Our Ref: P/40/22/NMA

**Section 96A of the Town & Country Planning Act 1990 (as amended)
Town and Country Planning (Development Management Procedure) (England) Order 2015
(as amended) - Article 10**

Non-material amendment following grant of P/70/19/RES to change some brick types on the Materials Schedule to some of the dwelling plots (Plots 51-52, 86-87 and 88-89) and replace rooflights to some plots to dormer windows (Plots 51-52, 86-87 and 88-89).

Land To The West Of Pagham Road Pagham PO21 4NG

DRAWING TITLE	
HICKSTEAD - Plot-86-87	
Elevations	
DRAWING STATUS	
PRELIMINARY ISSUE	
PROJECT NO. DRAWING NO.	1:50 @ A1
1177-WD-461	REVISION F
	DRAWN BY SS

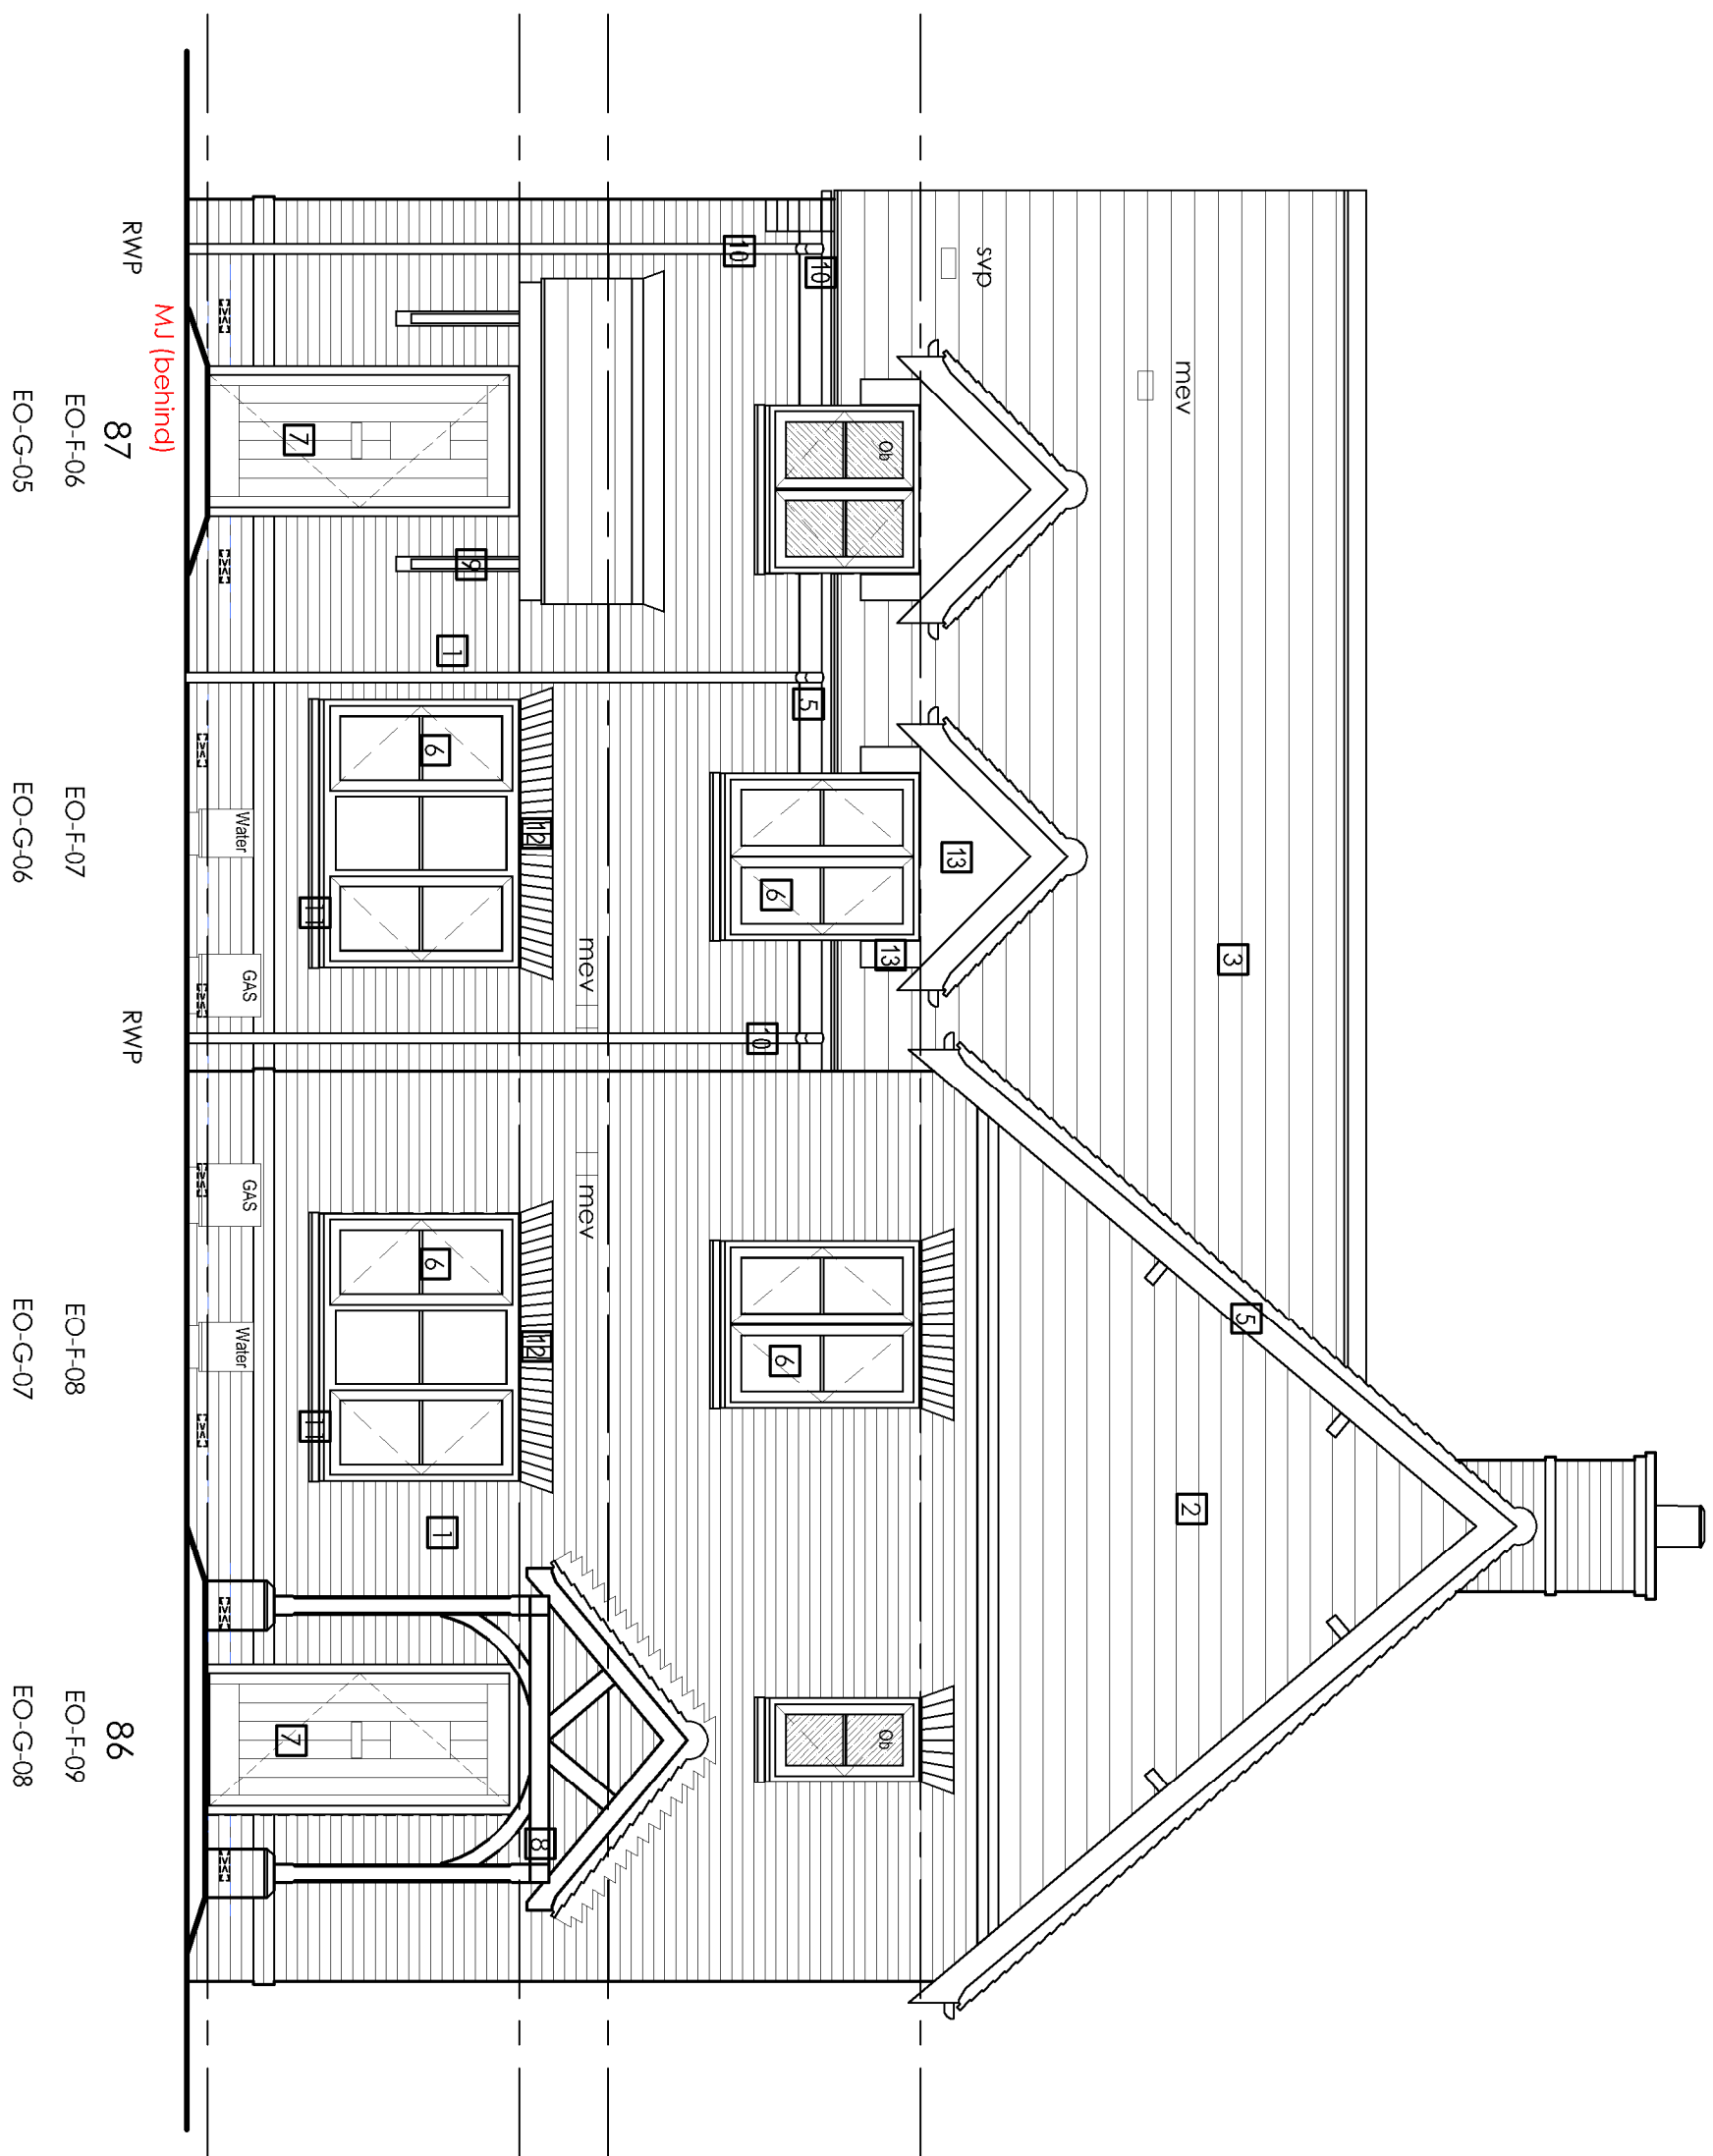
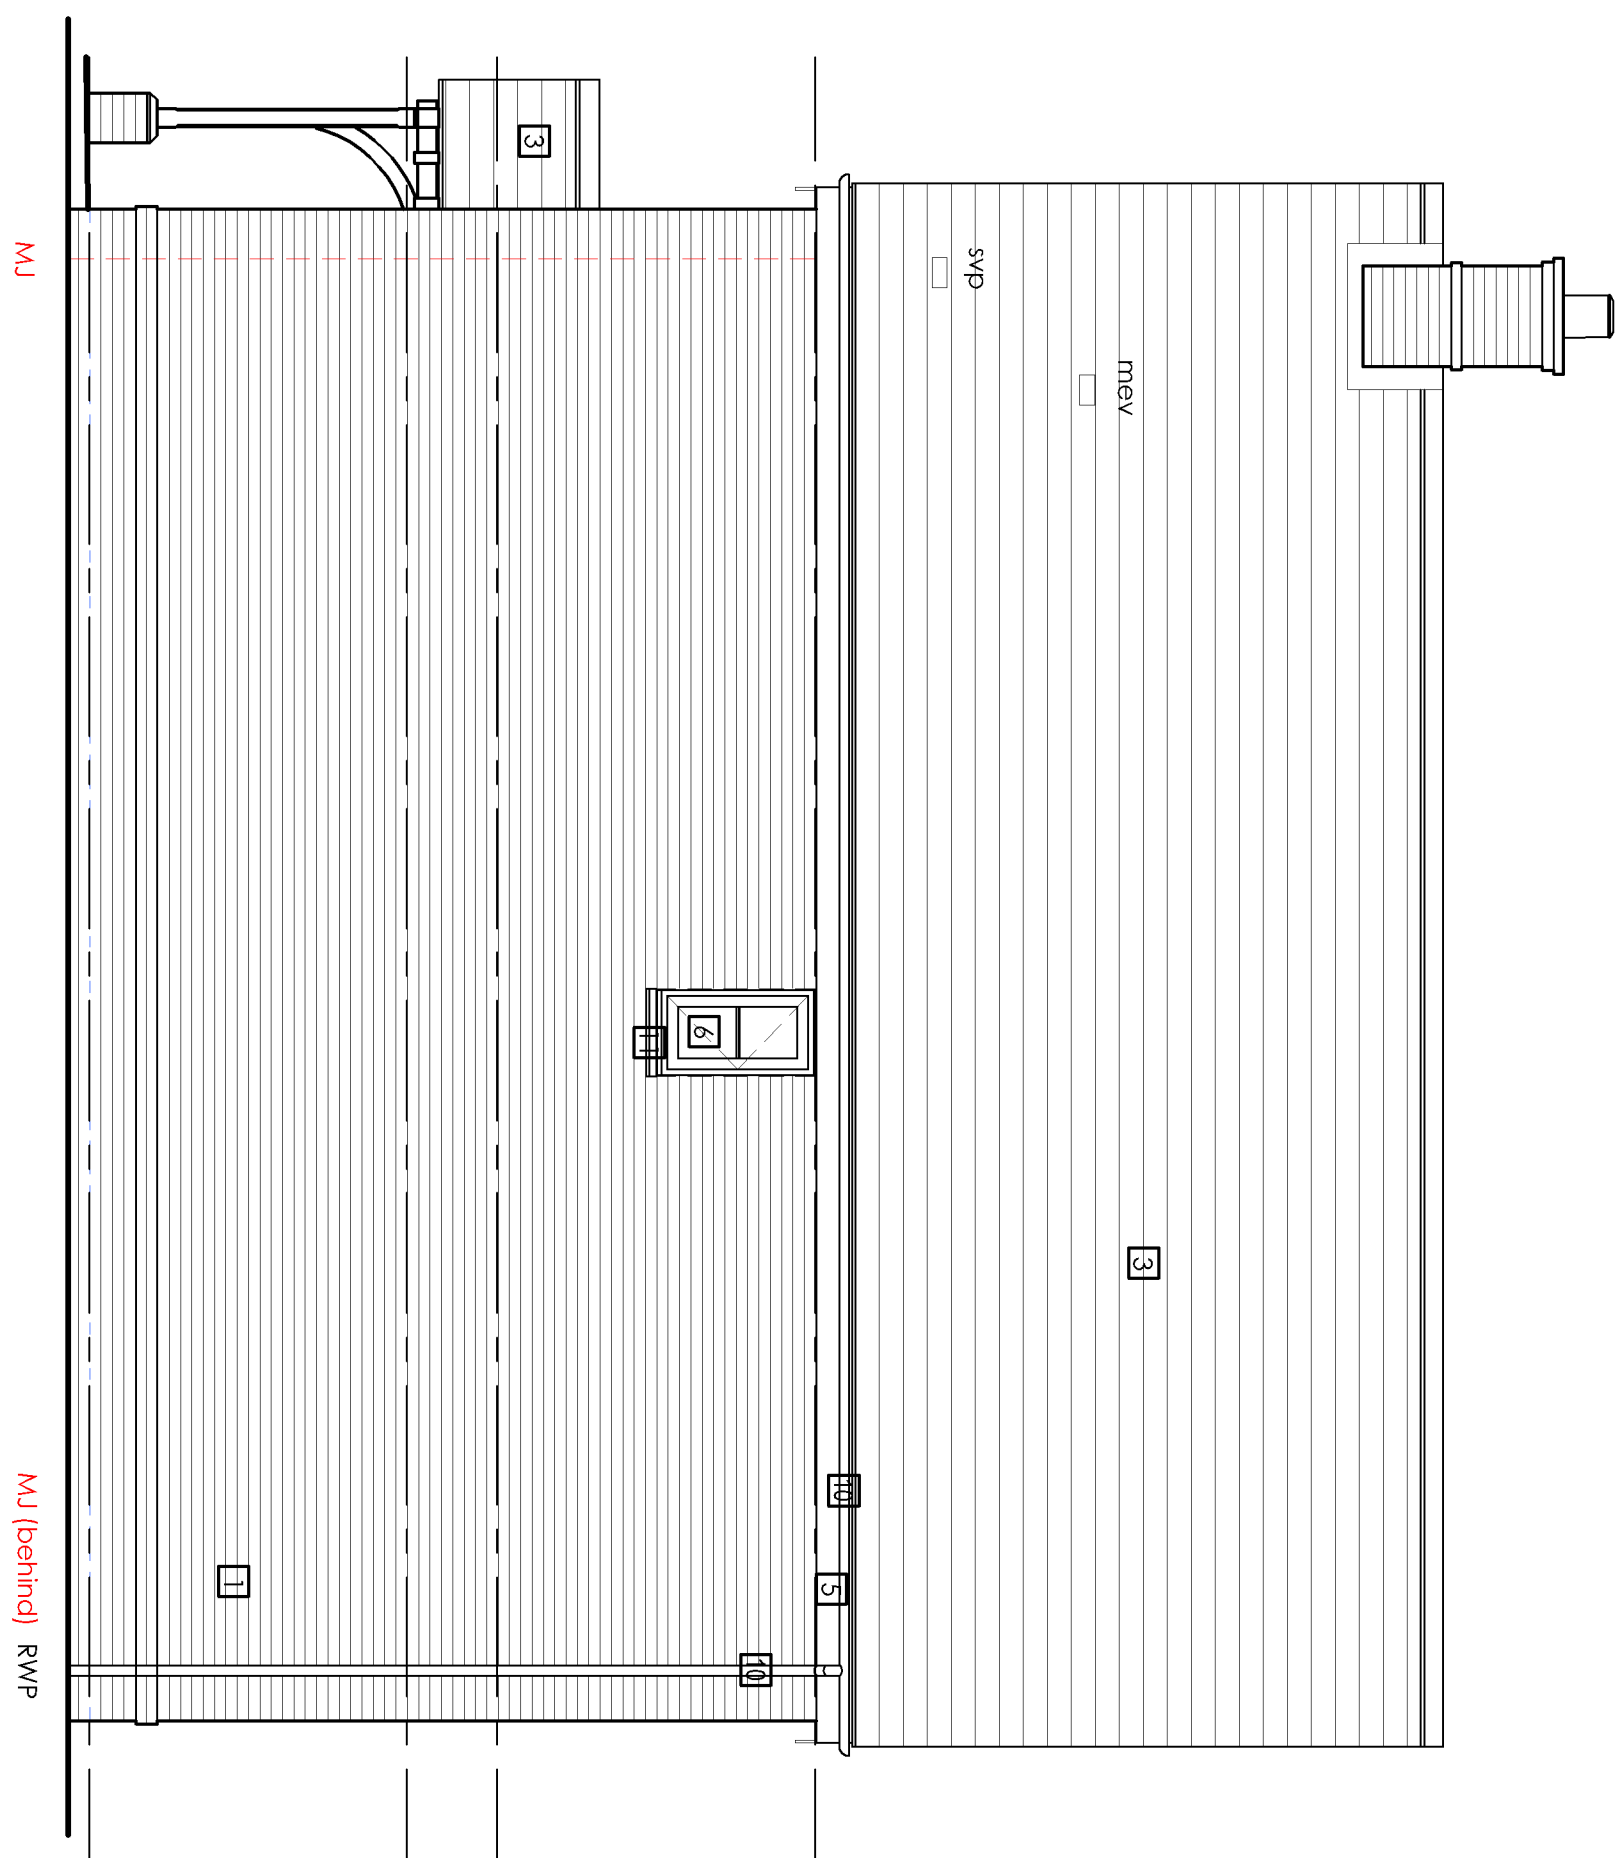
- use Ibstock Thakeham Red Multi Stock to some of the plots;
- use Vandersanden Sundridge Handmade Stock instead to some of the plots;
- replace roof lights on the fronts of the Hickstead house type (plots 51-52 & 86-89 only) with small dormers to match those already on the front and rear elevations.
